RE: Drainage Letter for Falcon High School – Building Expansion

Please add El Paso County  
project number , PPR 17-048.

# DRAINAGE LETTER FOR FALCON HIGH SCHOOL

FALCON HIGH SCHOOL
DRAINAGE LETTER MAP
2366.92
AUG. 11, 2017
BUILDING EXPANSION

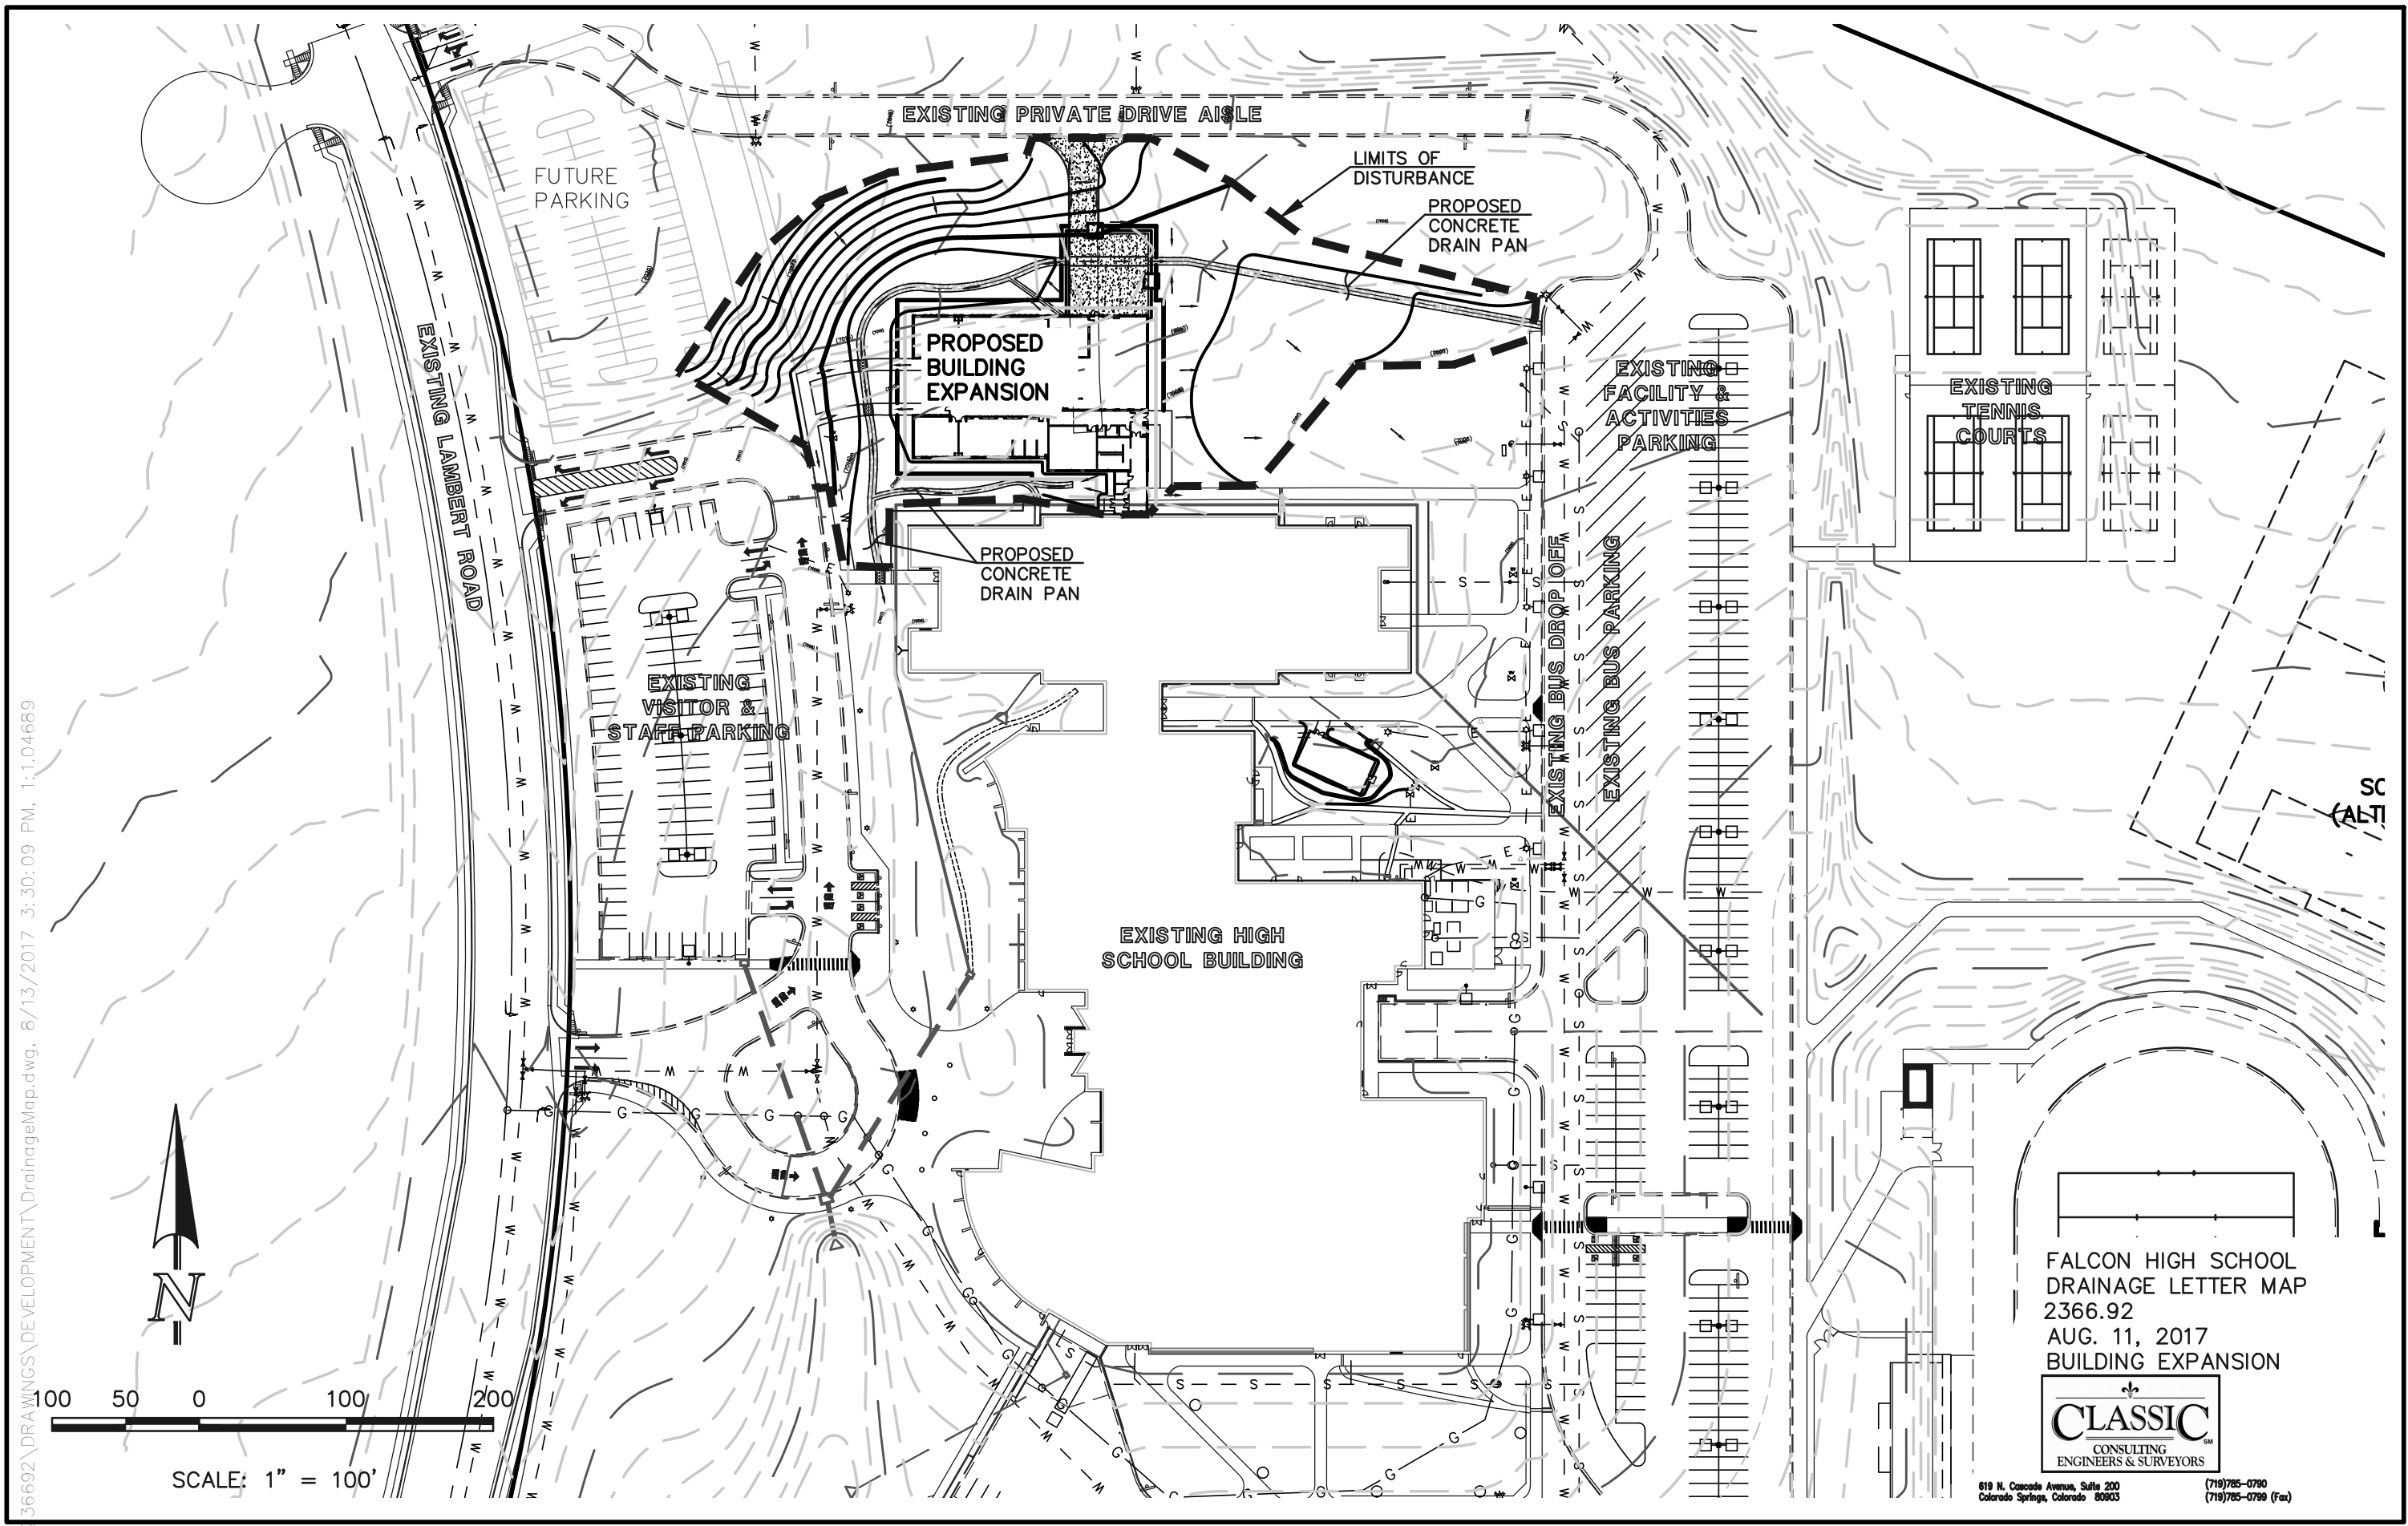
**Please call out ownership and maintenance responsibility for the ponds. Please also provide an exhibit that shows the location of the ponds.**
